**EL PASO COUNTY PLANNING AND
 COMMUNITY DEVELOPMENT
 DEPARTMENT**

STORMWATER MANAGEMENT PLAN CHECKLIST

~~PPR 000~~ **PPR219** Used 2110

Site is within the existing Pre-Dev Permit, individual lot grading plan has been updated and included in the report

GRADING & EROSION CONTROL PLAN
CLAREMONT BUSINESS PARK 2 FIL. NO. 1 - LOT 4
JOB NO. 44-037
DATE PREPARED: FEBRUARY 15, 2021
DATE REVISED: APRIL 21, 2021

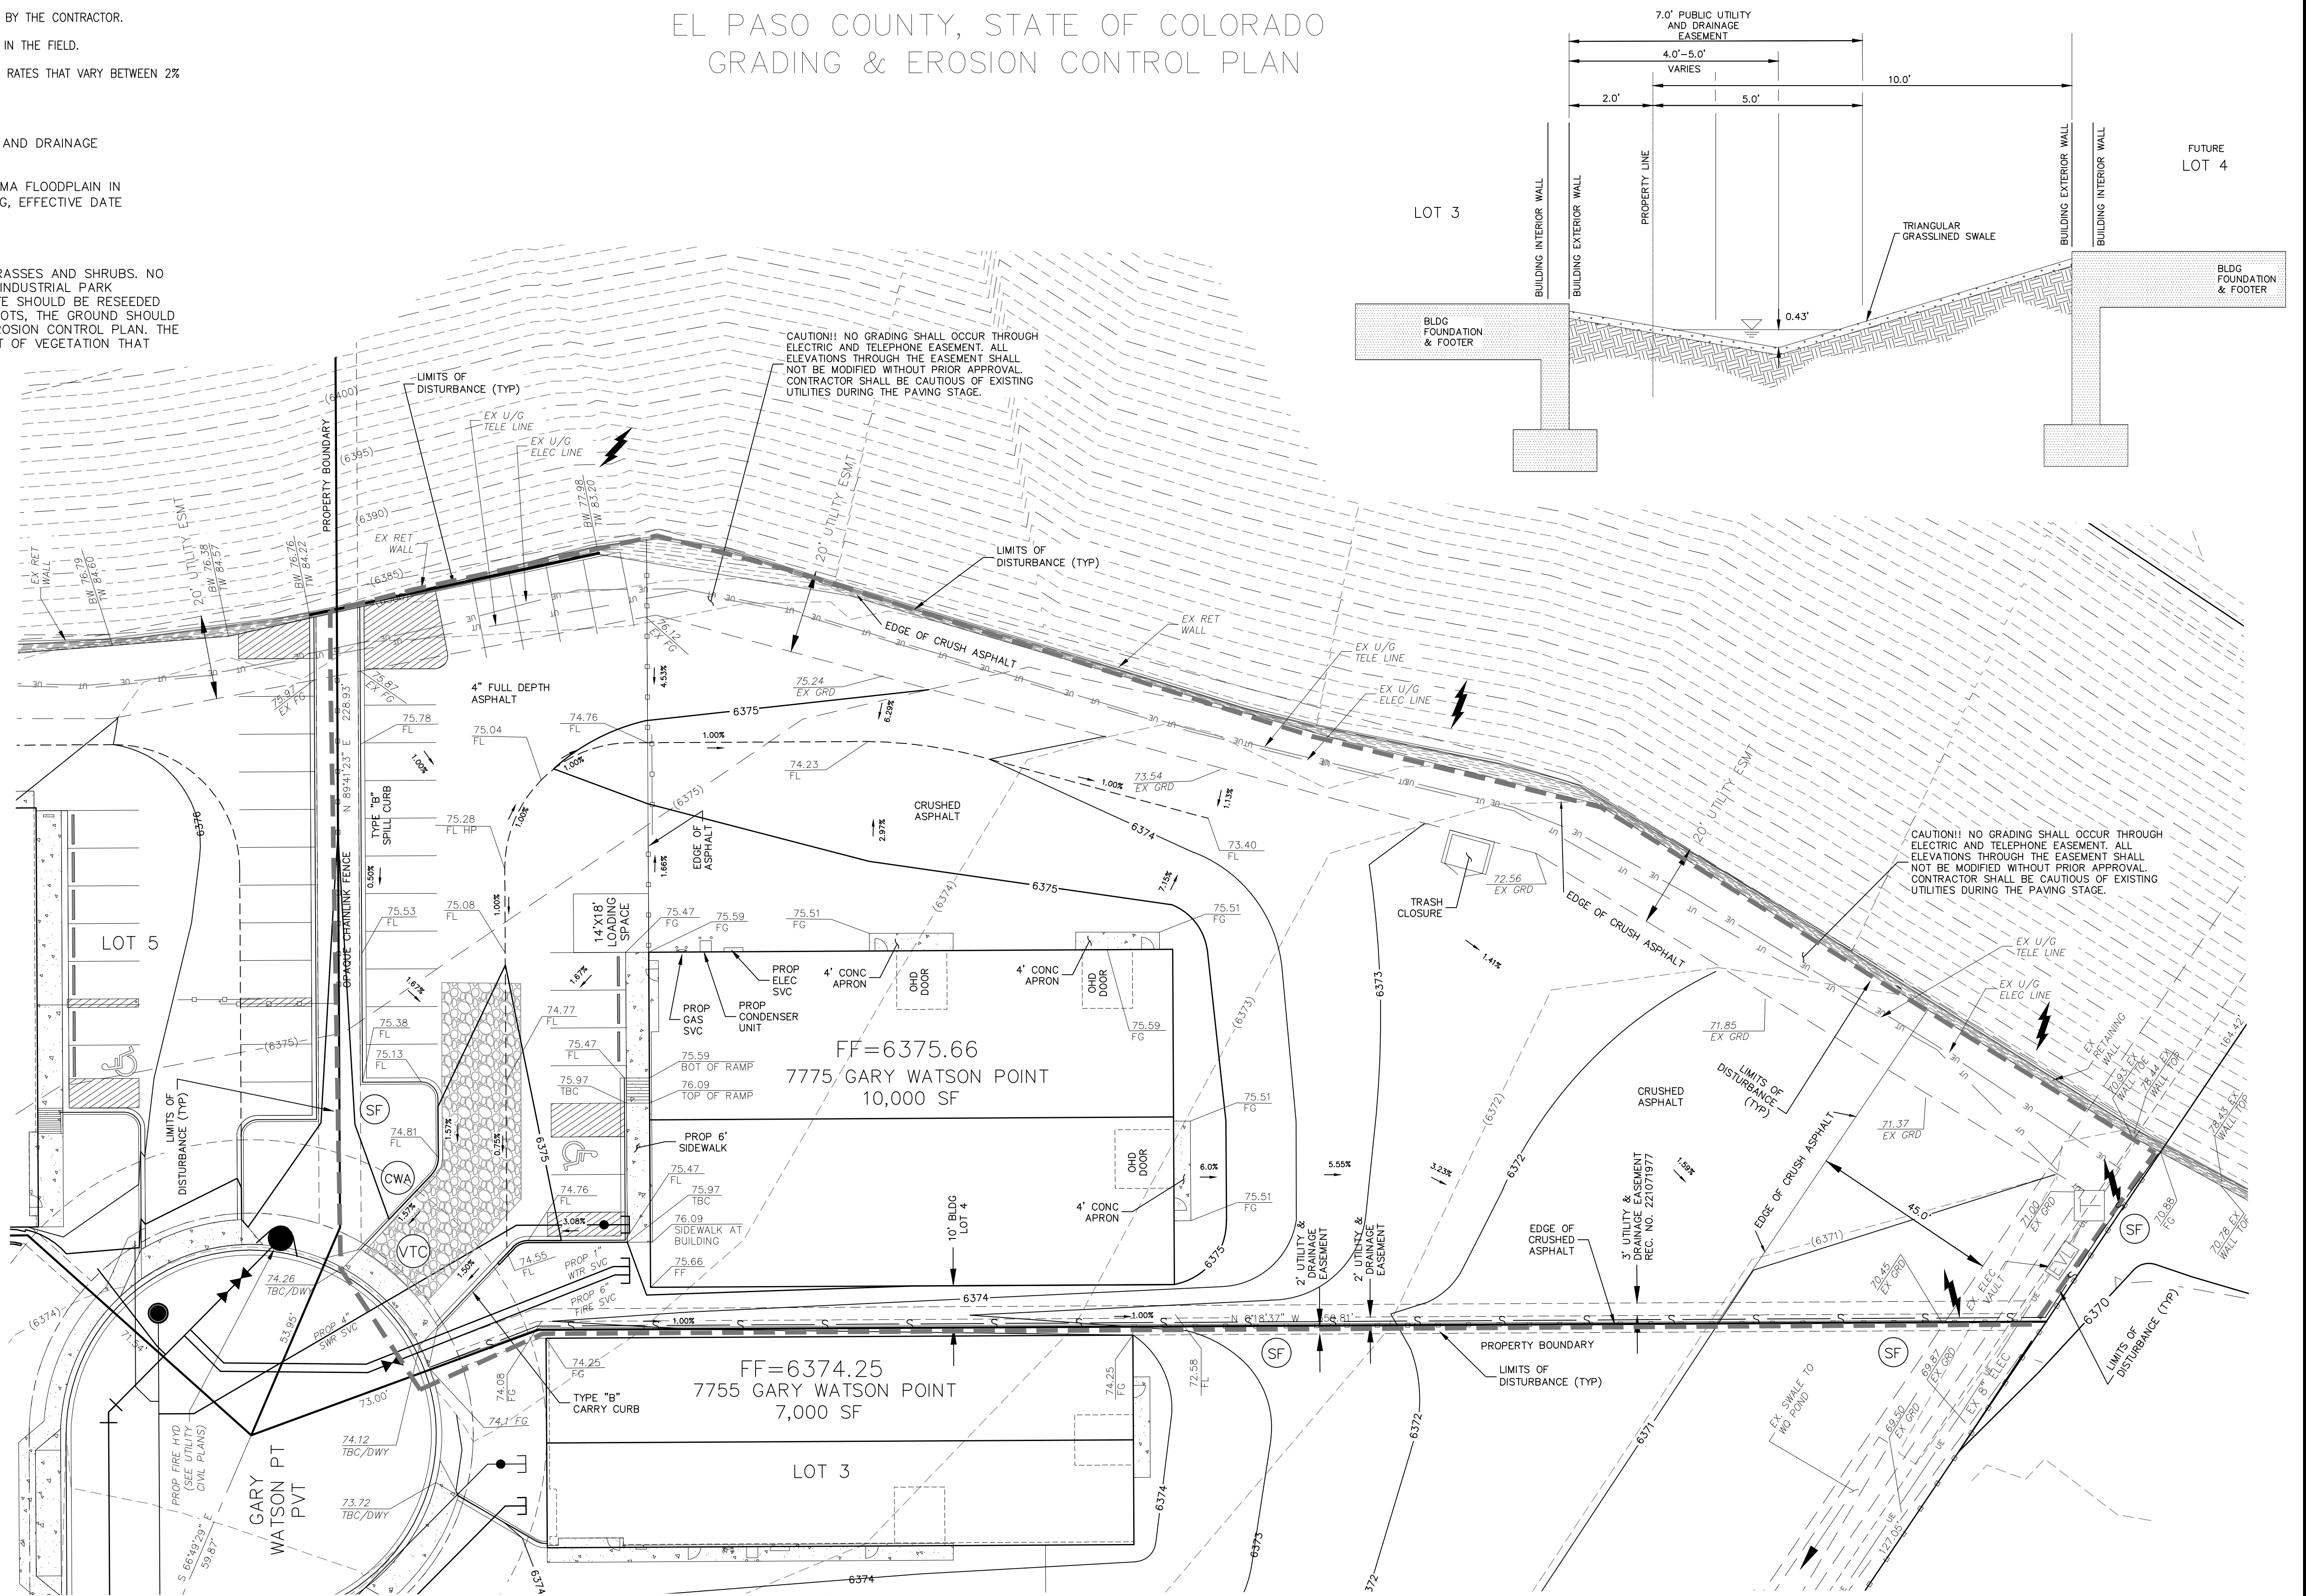
Revised: July 2019		Applicant	PCD
17	SWMP Map to include:	X	
17a	construction site boundaries	X	X
17b	flow arrows to depict stormwater flow directions	X	✓
17c	all areas of disturbance	X	✓
17d	areas of cut and fill		X
17e	areas used for storage of building materials, soils (stockpiles) or wastes	X	✓
17f	location of any dedicated asphalt / concrete batch plants	N/A	X
17g	location of all structural control measures	X	X
17h	location of all non-structural control measures	X	X
17i	springs, streams, wetlands and other surface waters, including areas that require maintenance of pre-existing vegetation within 50 feet of a receiving water	X	X
18	Narrative description of all structural control measures to be used. Modifications to EPC standard control measures must meet or exceed County-approved details.	X	✓
19	Description of all non-structural control measures to be used including seeding, mulching, protection of existing vegetation, site watering, sod placement, etc.	X	✓
